Recommendation Report for Planning Permission**REF NO:** R/77/14/PL**LOCATION:** Church of St Peter & St Paul
The Street
Rustington**PROPOSAL:** Construction of extension to south side of church. This application affects the character and appearance of the Rustington Conservation Area (resubmission following R/188/13/).**SITE AND SURROUNDINGS**

DESCRIPTION OF APPLICATION	As above The proposal relates to a single storey extension on the south side of the church measuring 4.25m x 4.9m which would be linked to the existing choir vestry.
SITE AREA	N/A
RESIDENTIAL DEVELOPMENT DENSITY (NET)	N/A
TOPOGRAPHY	Predominantly flat.
TREES	One protected holly tree would be affected by the proposed development.
BOUNDARY TREATMENT	Flint walling around perimeter of churchyard
SITE CHARACTERISTICS	Existing 12th century church. Flint elevations. Arched windows. Grave stones and holly tree in area of proposed extension. Readily visible from path through church yard
CHARACTER OF LOCALITY	On edge of village centre. Mix of residential/retail and commercial. Public house opposite. Adjacent to public toilets and church hall to east.

REORDERING & EXTENSION:
ELEVATIONS AS PROPOSED

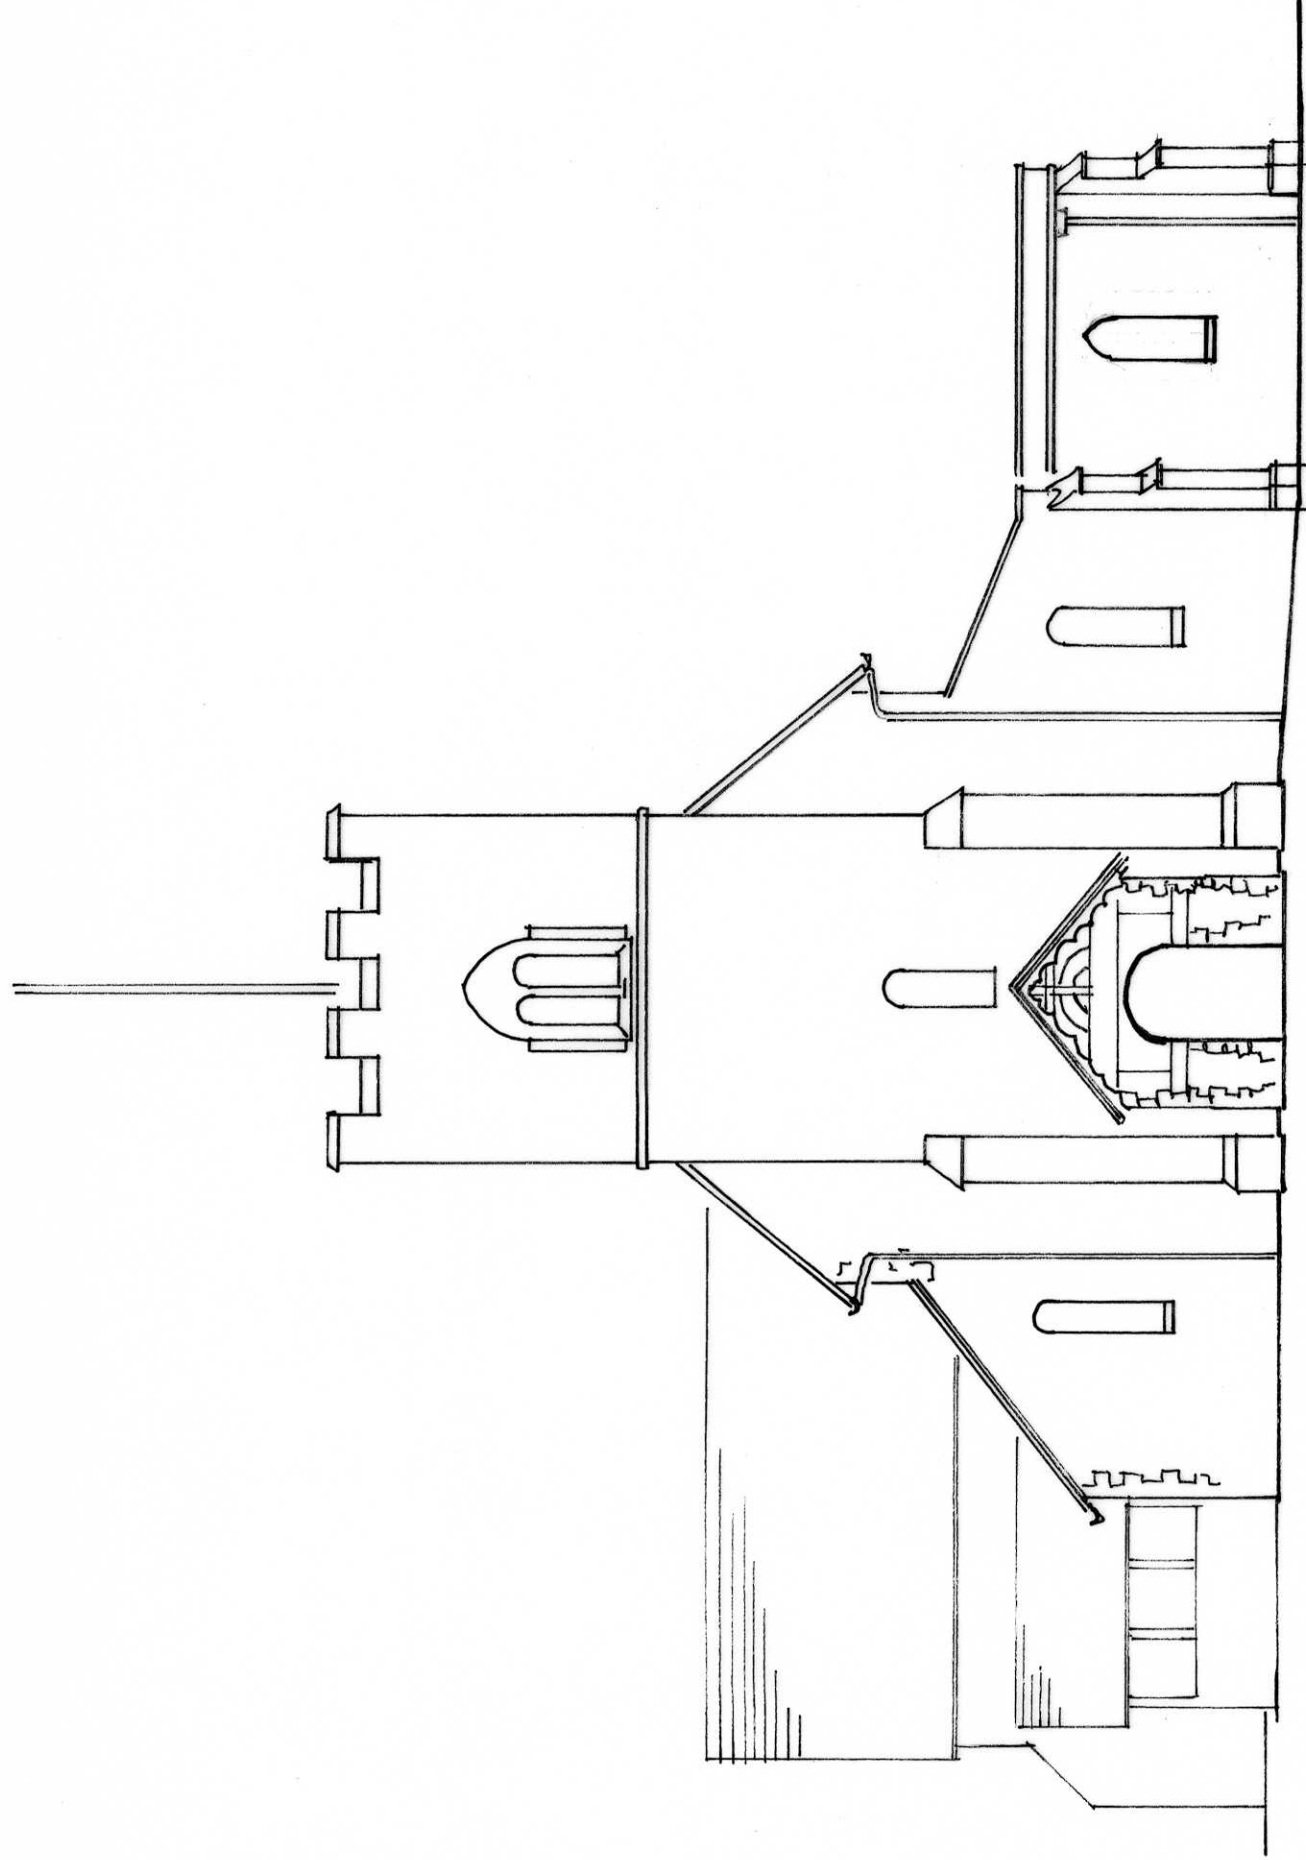
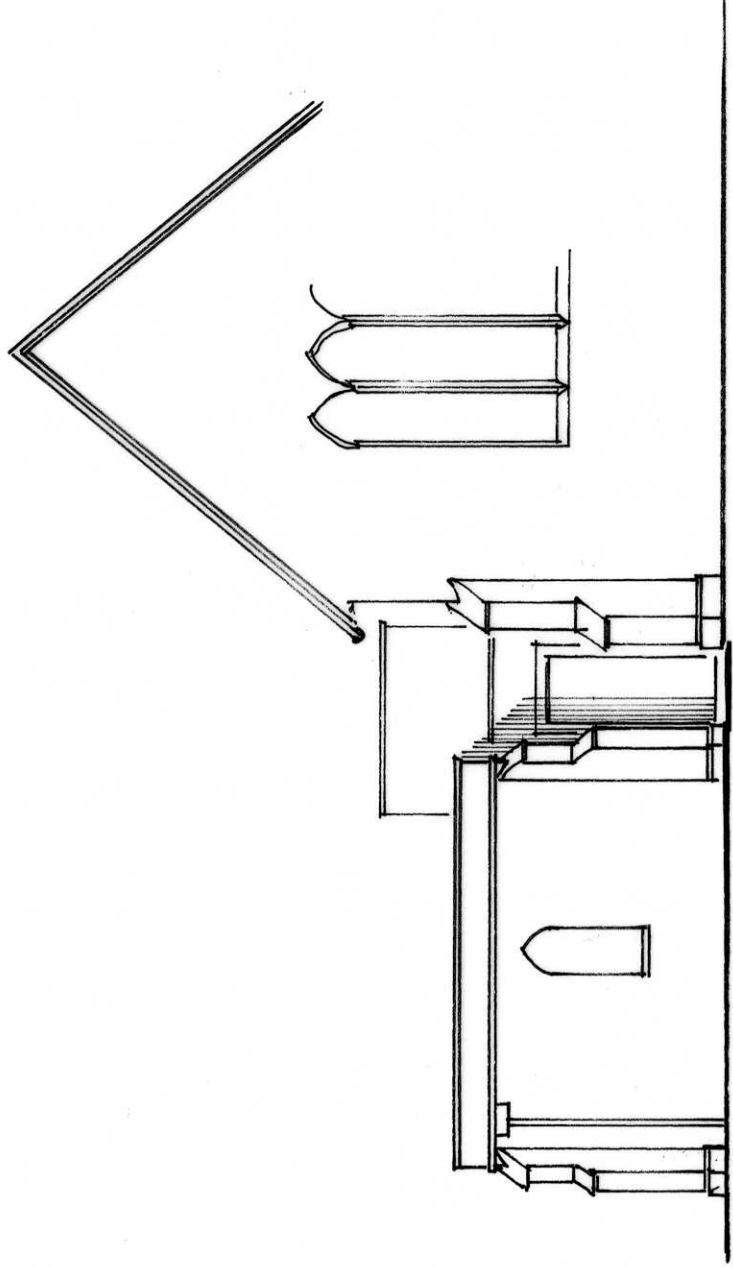
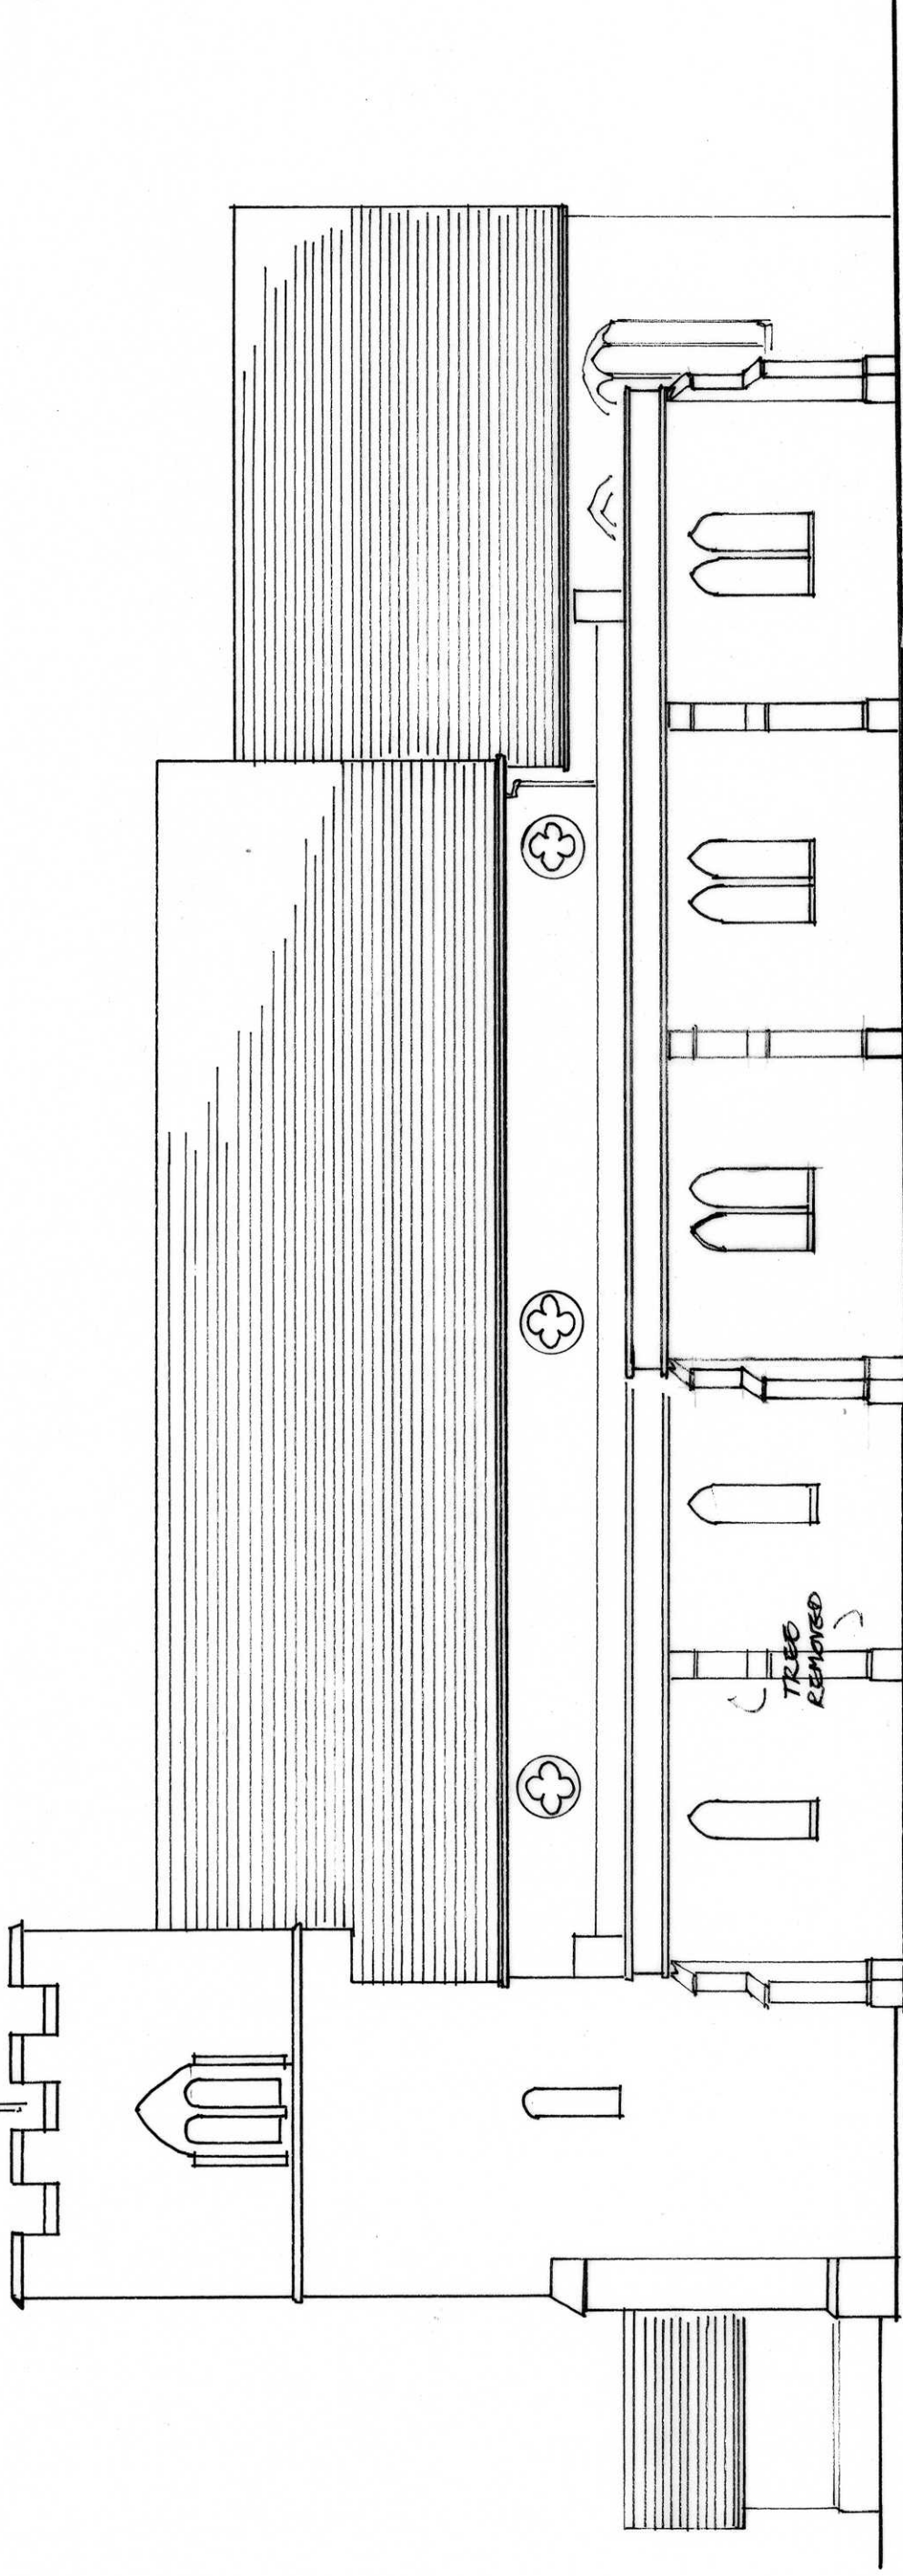
Further to our site visit and internal inspection, we are more comfortable with the proposed development, though would request that a sample panel of flint work is conditioned for approval. This work should be absolutely consistent with the existing flint walling for the scheme to be properly sympathetic. Please also condition the following details:

? windows

? roofing

? buttress

? parapet

- 4 No development shall be carried out unless and until a schedule of materials, details and finishes for the windows, roofing, buttress and parapet of the proposed extension have been submitted to and approved by the Local Planning Authority and the materials so approved shall be used in the construction of the extension.

REORDERING & EXTENSION:
VESTRY & AISLE WALL AS PROPOSED

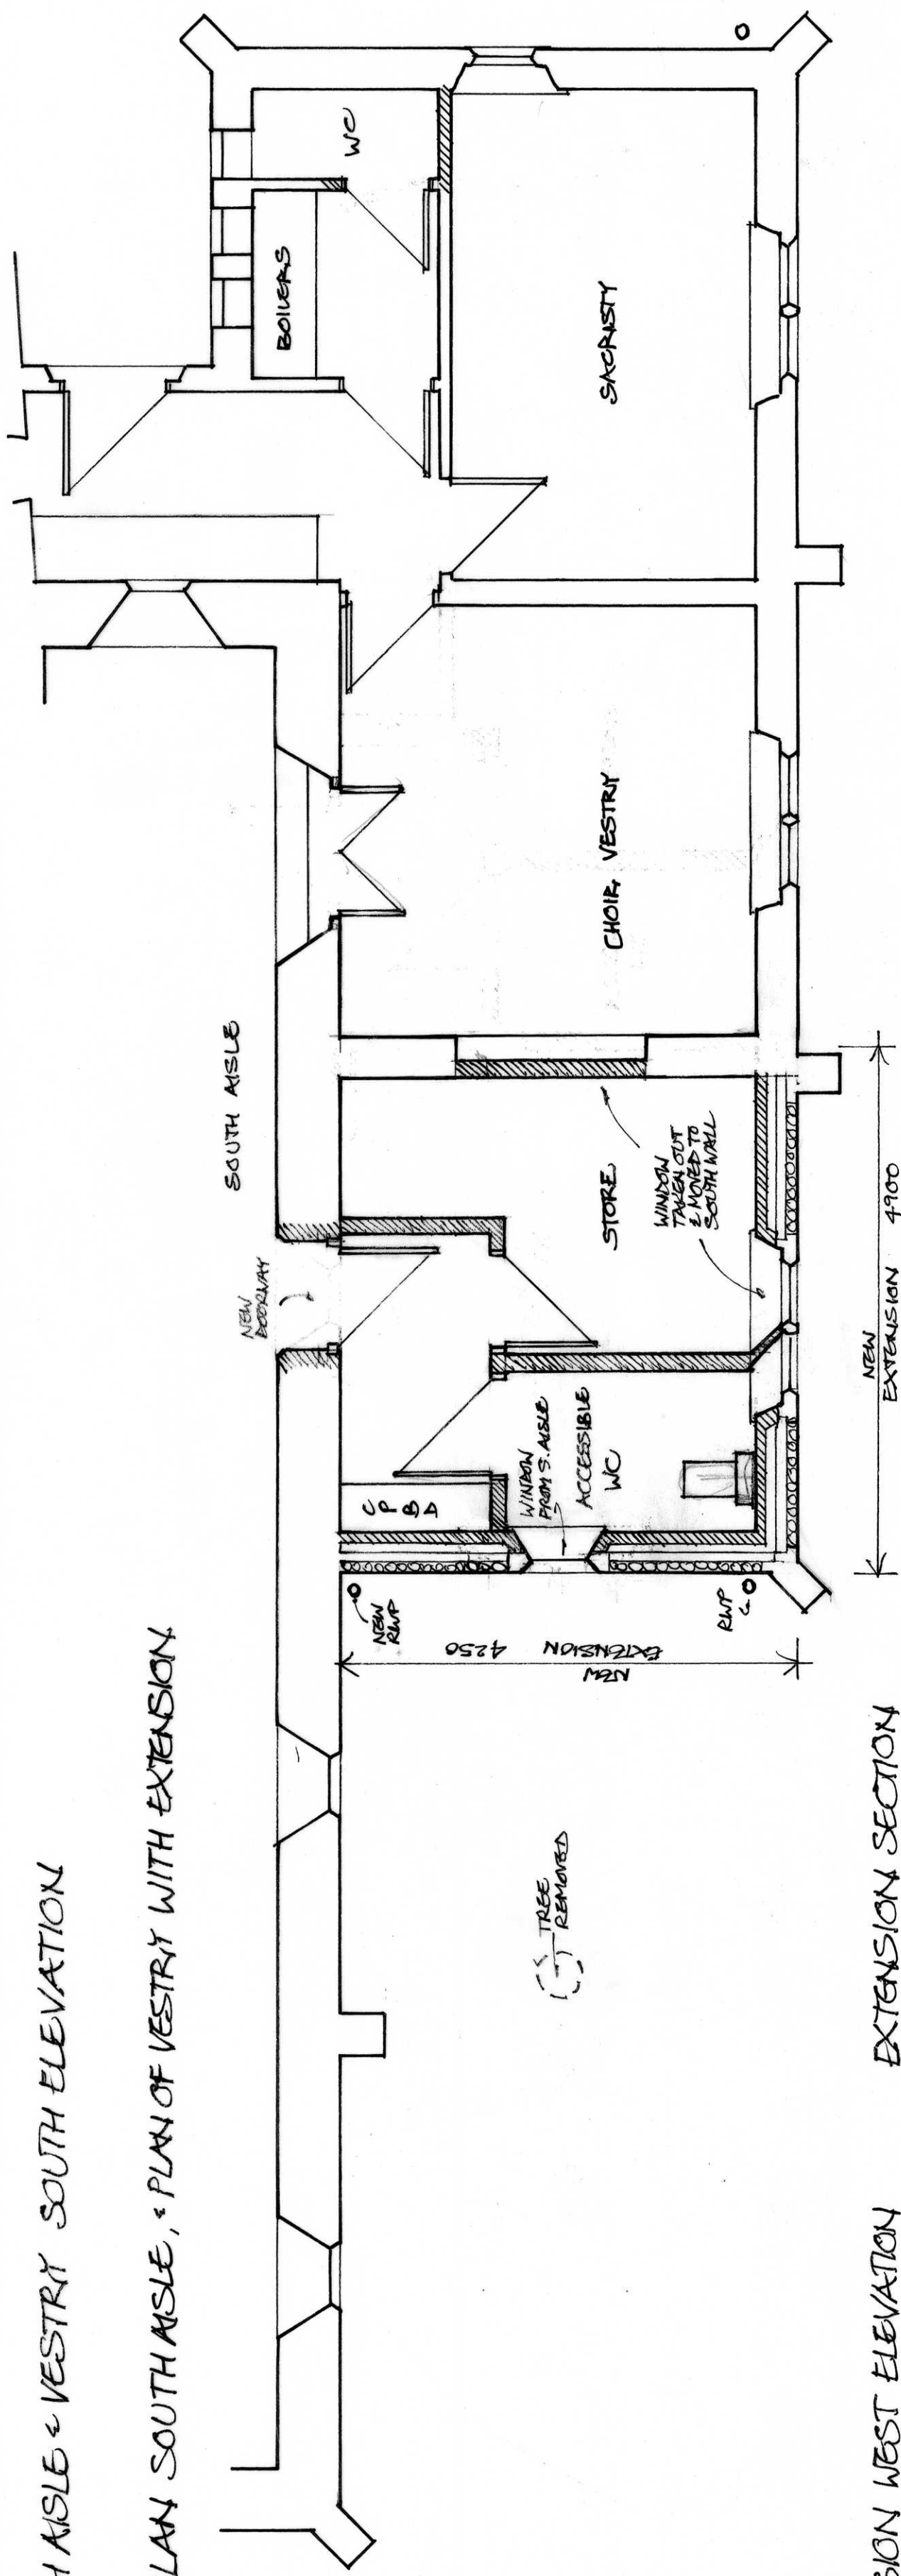
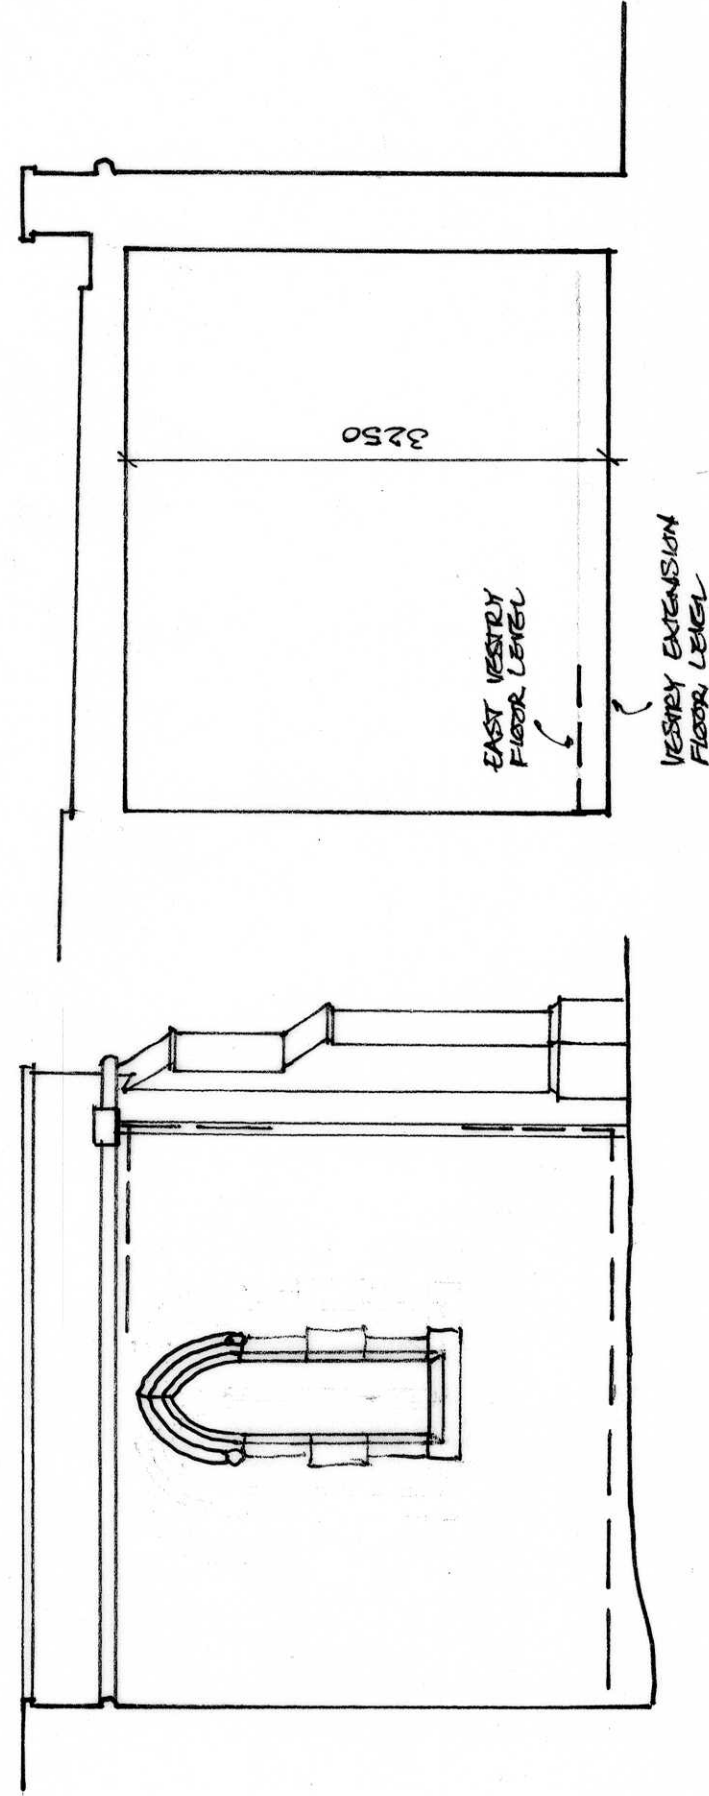
Flintwork on new extension should match exactly the existing quality.

The proposed works are now considered acceptable. However, this is subject to the new flint work matching that of the existing. A sample panel of the flint should therefore be conditioned for approval.

One window in the South aisle of the church will be removed and replaced by the access door to the new area. The window, which relates to one of the monuments to be re-positioned, will be placed on the outside wall of the extension and retained close to its related monument.

- 3 Any walling shall conform with a sample panel of flintwork which shall be erected on site and approved in writing by the Local Planning Authority before development commences and the development shall be carried out in accordance with the details so approved.
